Final Report - Corrections Required **Application No. ANEX-24-0004**

Report Date: 04/03/2024

Description : Matrix Design Group on behalf of Colorado Springs Equities LLC is submitting a serial annexation petition for seven parcels and Land Use Plan/Rezoning exhibit for a portion of the subdivision known as Rock Creek Mesa.

Document Filename : 224.023-SURV-RCM ANNEX PLAT 4.pdf

# ANNEXATION PLAT ROCK CREEK MESA ADDITION NO. 4

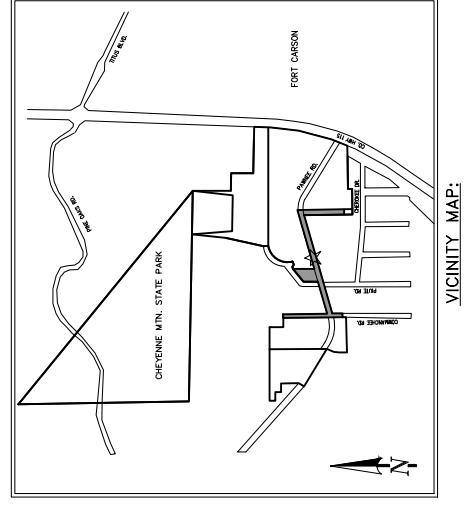
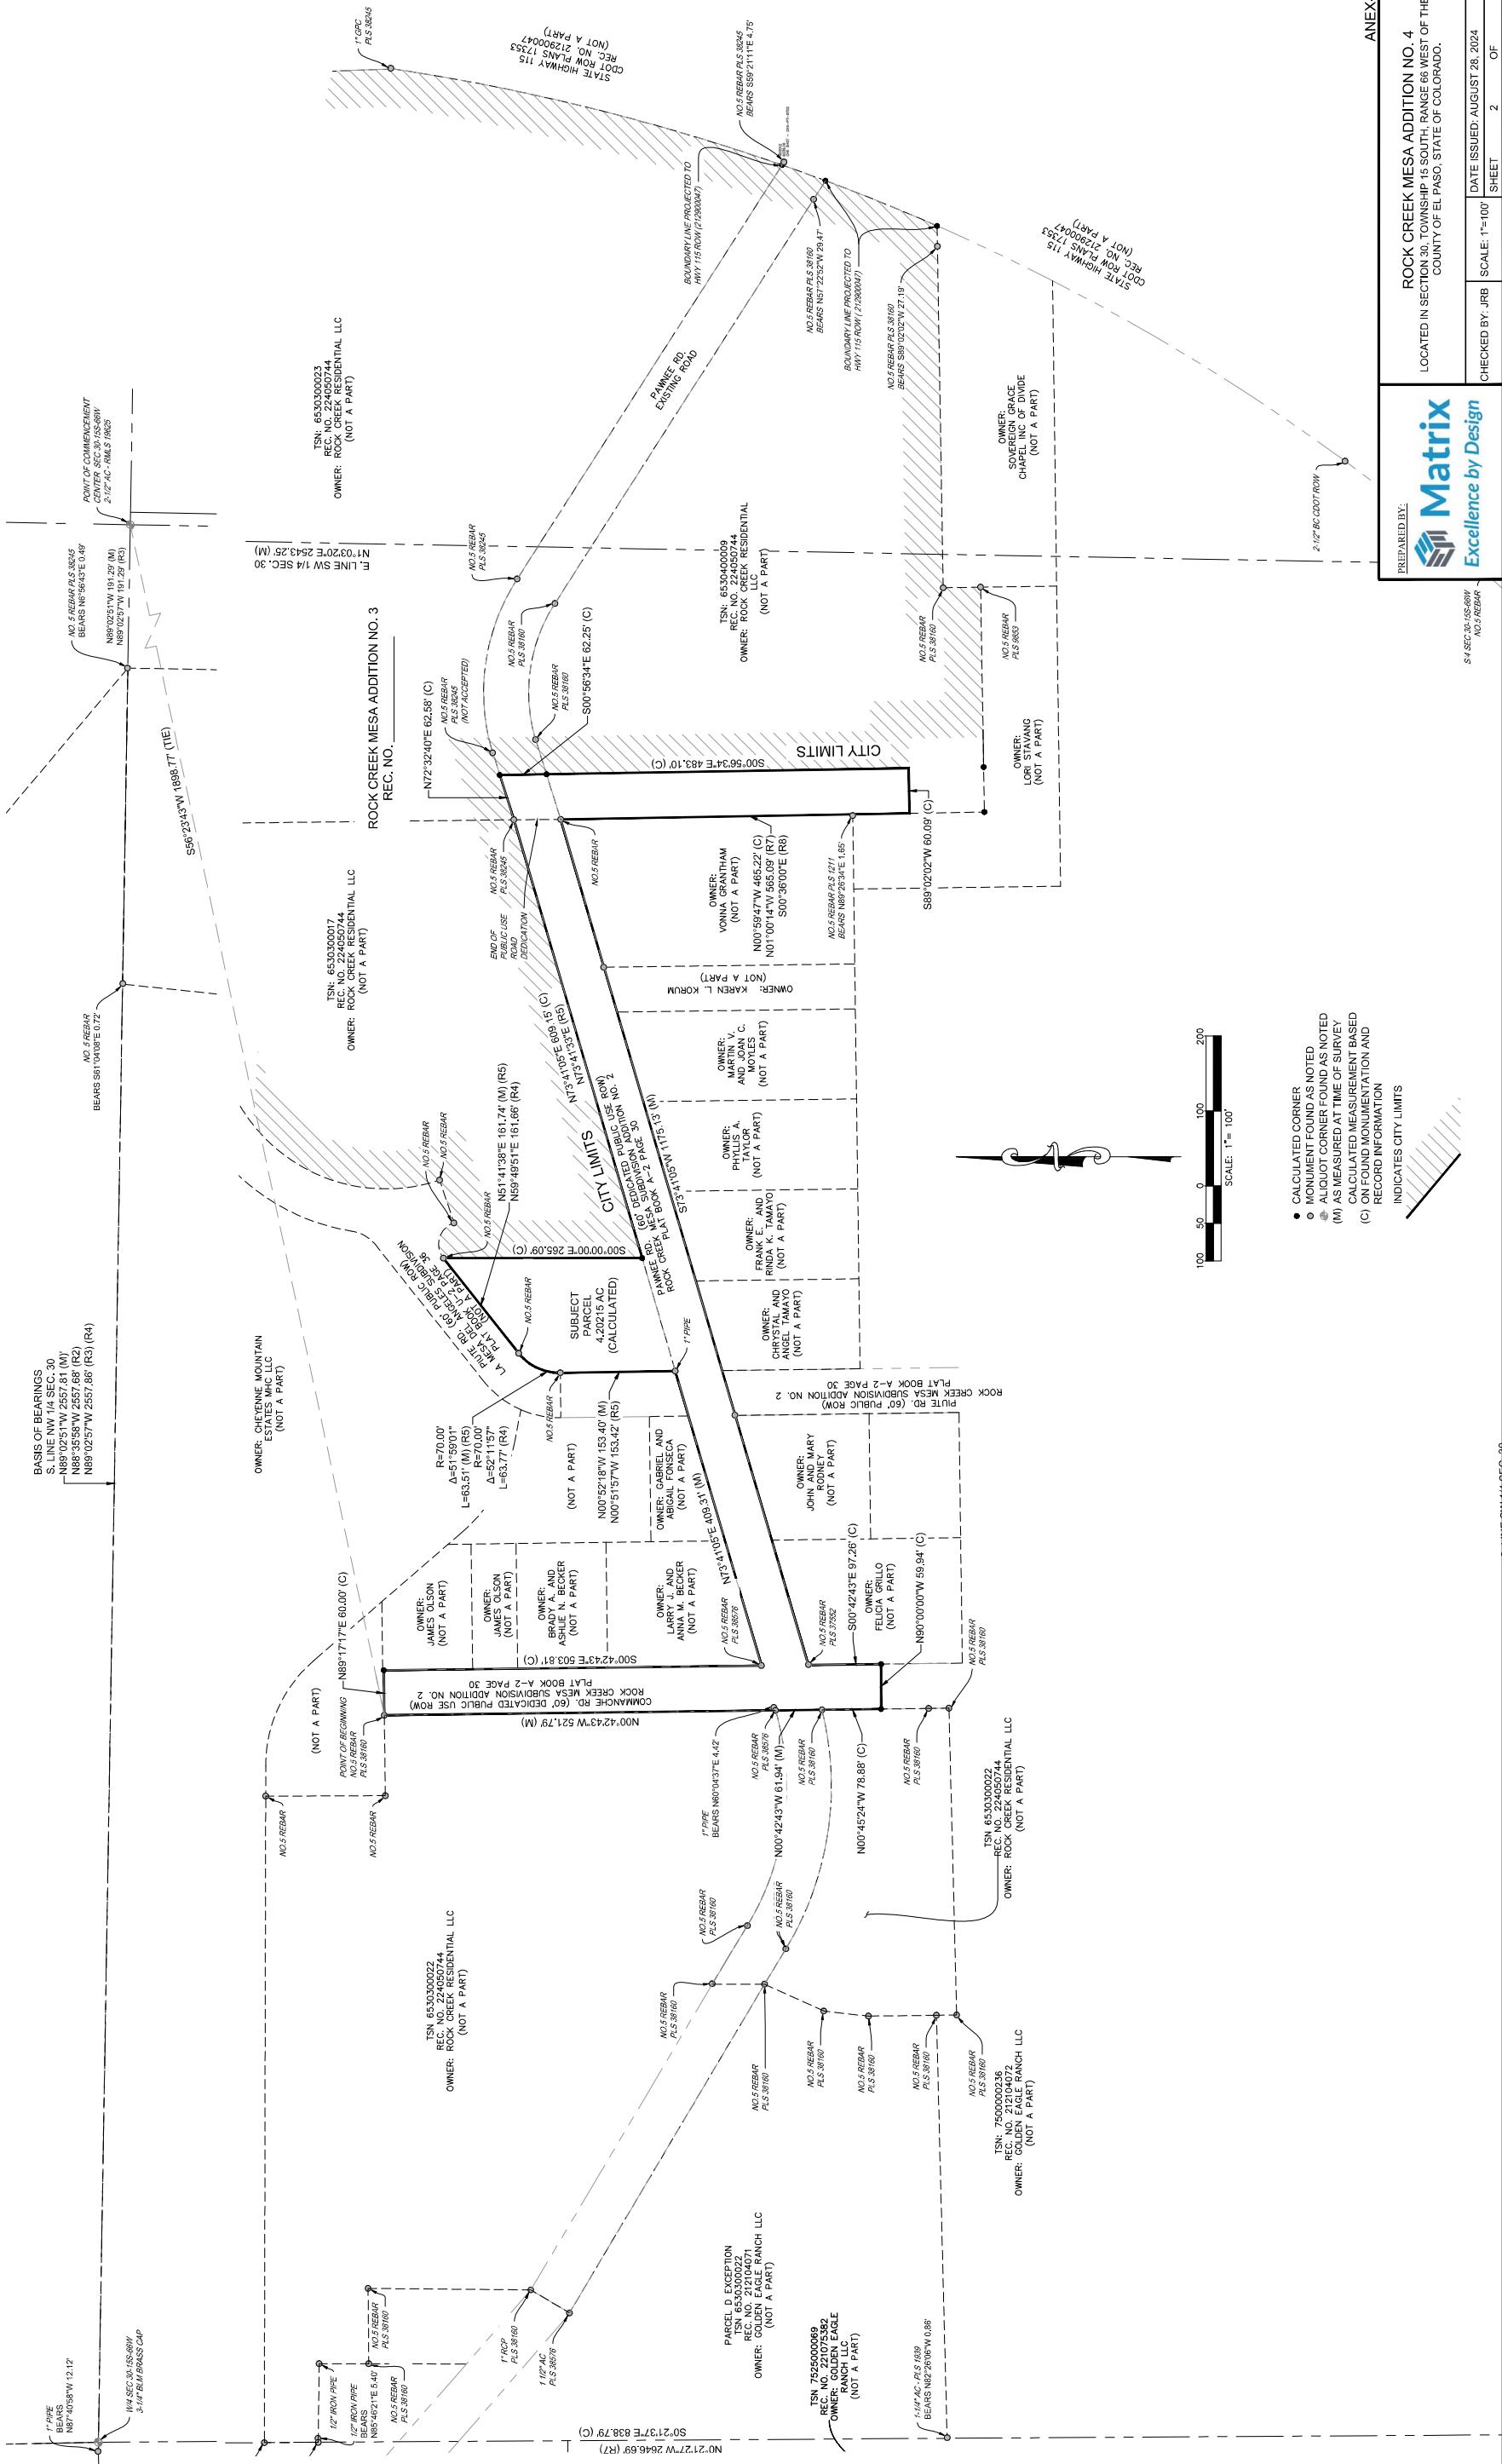
14	1	Sara Rivera : City Engineering - SWENT	The FEMA floodplain zone is incorrect. Please update to the correct zone.
2	1	Matthew Alcuran : Col Springs Utilities	<p>Please acknowledge the following Water Planning Informational Note: Please refer to the completed Hydraulic Analysis Report completed on November 2, 2023 for HR Green and SSS Education. Conclusions and Requirements:</p> <p>**Modeled fire flows are 2100 to 2200 GPM. No fire flow requirement was provided.</p> <p>**Either alternative presented in this report are acceptable.</p> <p>**Since all pressures are below 170 psi, PVC is acceptable.</p>
3	1	Matthew Alcuran : Col Springs Utilities	<p>Utility Comments (electric, gas, water, wastewater)</p> <p>1.Action Items:</p>

8	1	Matthew Alcuran : Col Springs Utilities	<p>Please response to CSU LBS comment: Have reviewed and entered geometry into FIMS.</p> <p>"In written legal on Plat , first item no. 1, edit 6009.15 FEET."</p>
18	1	Gabe Sevigny : Planning	ANEX-24-0004 to both all sheets
26	1	Cory Sharp : Planning	Please add the area at the end of the legal description
27	1	Cory Sharp : Planning	Shouldn't there be calls to and along HWY 115?
28	1	Cory Sharp : Planning	609.15'
29	1	Cory Sharp : Planning	Please check/revise the bearing S72-19-47W closure
30	1	Cory Sharp : Planning	<p>Please update 3, 4 & 5 to the following contiguity statement:</p> <p>contiguity statement:</p> <p>Total Perimeter of the Area for Annexation: 5,150.60' One-Fourth (1/4th) of the Total Perimeter: 1,287.65' (25.00%) Perimeter of the Area Contiguous to the Existing City Limits: 1,292.50' (25.09%)</p>
31	1	Cory Sharp : Planning	Please add quotations around the plat name "Rock Creek Mesa Addition No. 4"

19	2	Gabe Sevigny : Planning	Question for Surveyor, does this resolve the road issue?
20	2	Cory Sharp : Planning	Please provide a copy of recorded quitclaim. Is this an easement, right-of-way etc.?
32	2	Cory Sharp : Planning	Please clearly depict all the city limits not just that adjacent portion
33	2	Cory Sharp : Planning	Please depict and label the basis of bearings and add a tie to the point of beginning so all the additions can be tied together
34	2	Cory Sharp : Planning	Please add alabel for Rock Creek Mesa Addition No. 3
35	2	Cory Sharp : Planning	Please remove Rock Creek Mesa Addition No. 4
36	2	Cory Sharp : Planning	Please revise the bearing N90-00-00E
37	2	Cory Sharp : Planning	L=394.71' closure and legal
38	2	Cory Sharp : Planning	Please add)M) and (C) to the legend
39	2	Cory Sharp : Planning	It would be helpful to change the text style of the ownership information so that it is clearly informational text

40	2	Cory Sharp : Planning	Please remove the areas from all adjacent parcels

Comment ID	Page Reference	Reviewer : Department	Review Comments
41	2	Cory Sharp : Planning	Please clearly label the adjacent areas *not a part* for clarity
42	2	Cory Sharp : Planning	It would be easier for review if the adjacent areas were a dashed line type please review and adjust accordingly
